19 July 2016

File Number: 2014/6840  
Our Ref: R/2014/44/B

**RE: SSD 6840 MOD 1 – Modification Application – St Vincent's Private Hospital Sydney**

DEMOLITION LAYOUT - LEVEL 4

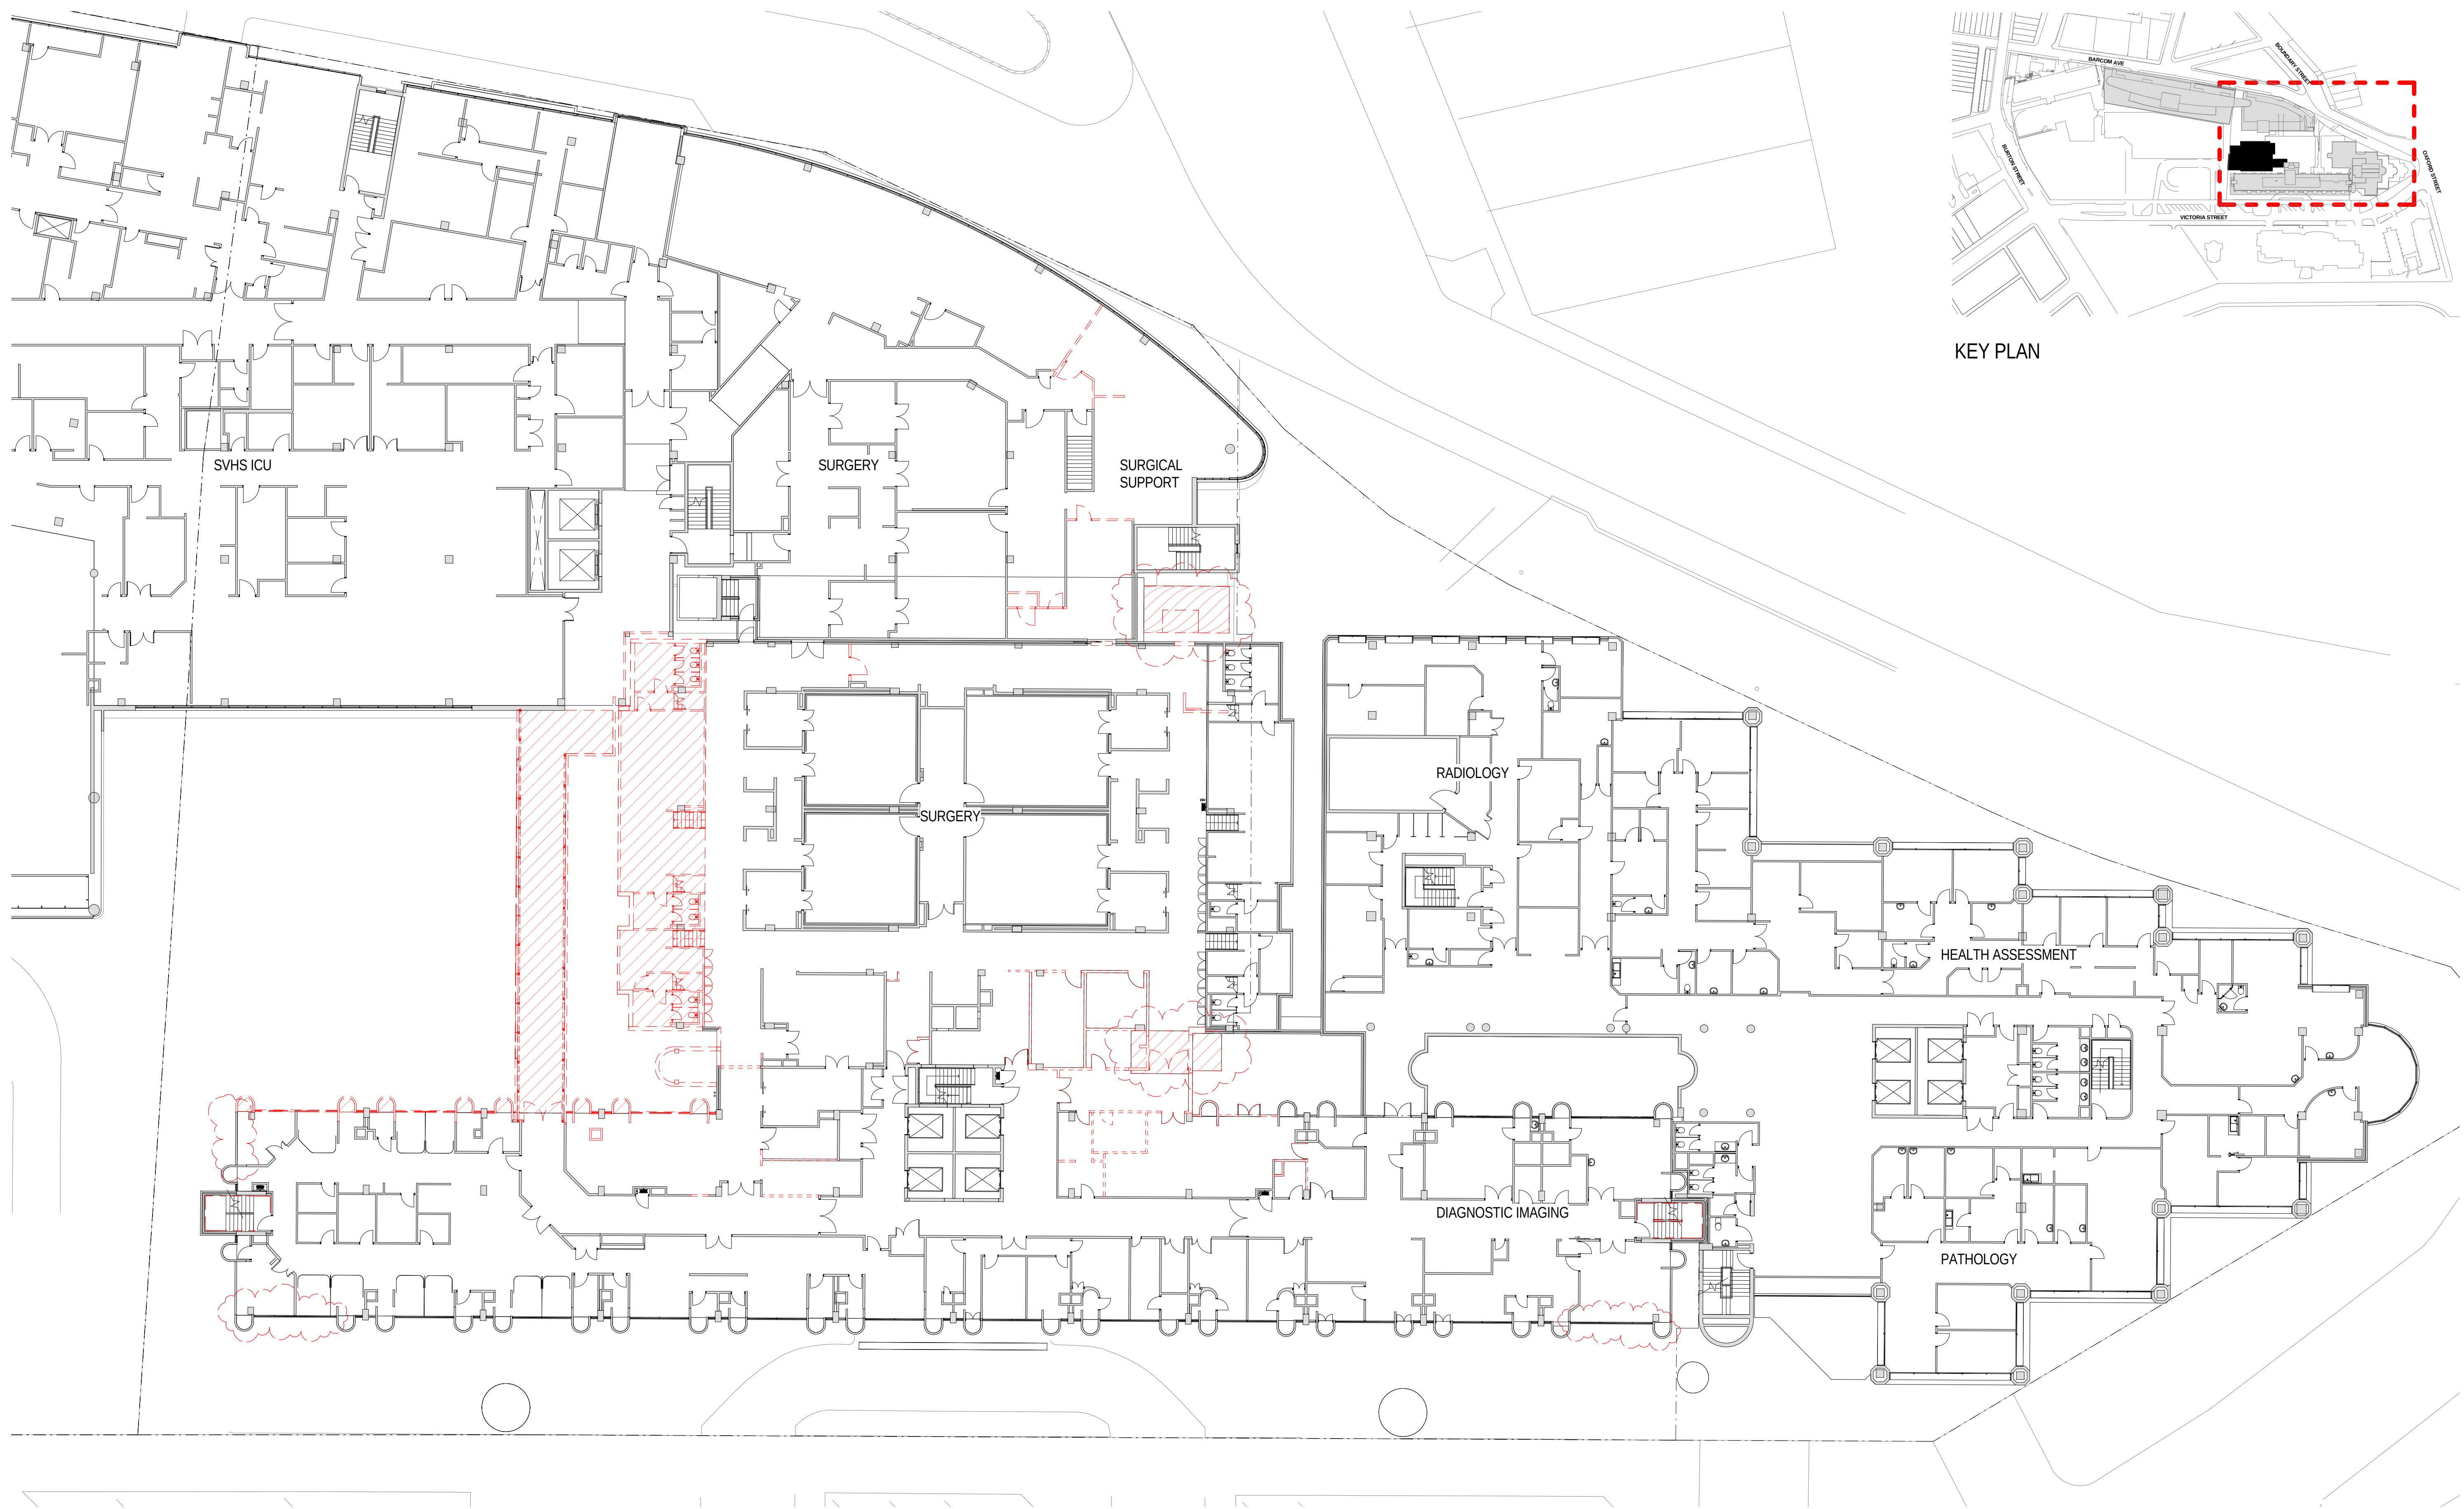
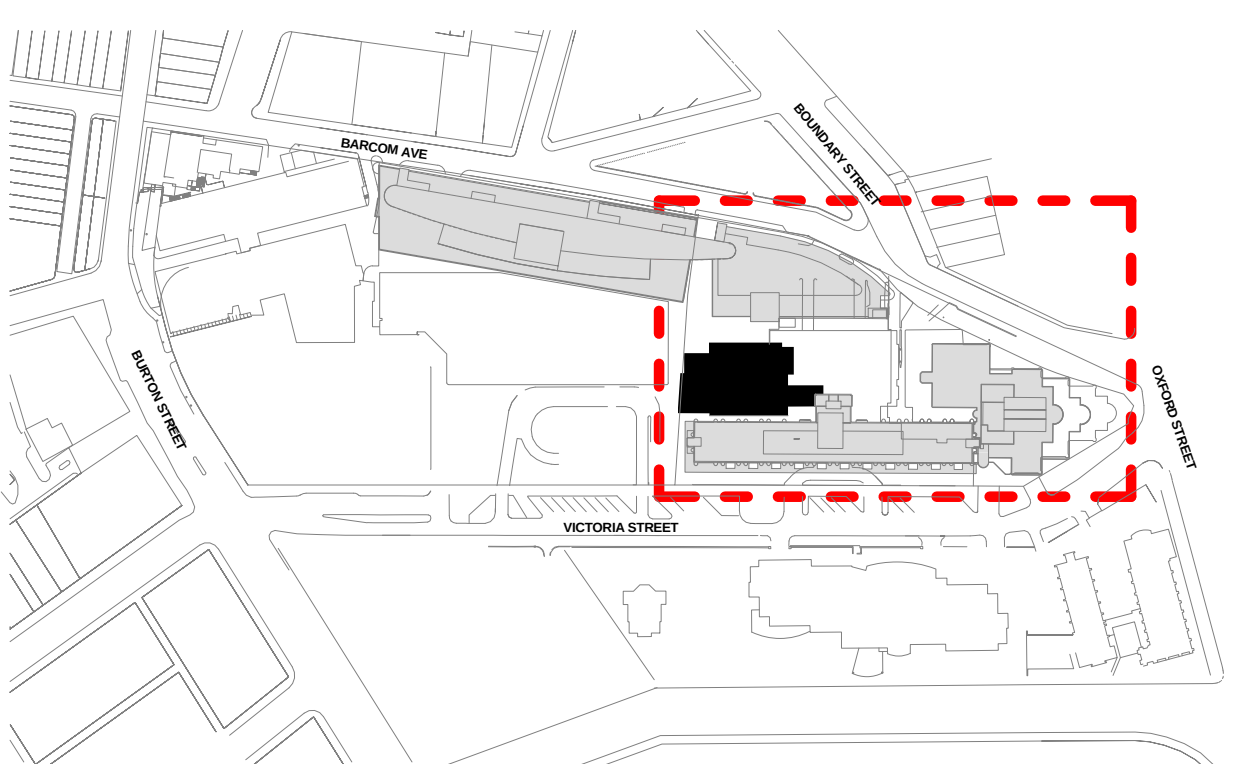
Section 2.1 of the revised Statement of Environmental Effects contains a schedule of proposed modifications. This includes the removal of seven trees within the north eastern portion of the site identified on drawing number DA-00-802 (Rev. E). It is noted an Arborist Report has not been submitted with the application, nor has the removal of trees been further addressed within the SEE.

On 14 July 2016, Council Officers undertook an inspection of the St Vincent's Hospital site. The inspection revealed that the trees nominated for removal on drawing number DA-00-802 (Rev. E) have already been removed from the site. In the event these trees have been removed without consent, Council recommends further investigation and action by the Department of Planning and Environment.

The subject modification seeks consent for an 'increase to the extent of the demolition area' at Level 4 (annotated on DA-00-802 (Rev. E). In this regard, Council recommends a modification to consent conditions requiring any additional demolition and/or excavation works associated with the subject proposal to be considered and adequately addressed within an amended DESI where relevant.
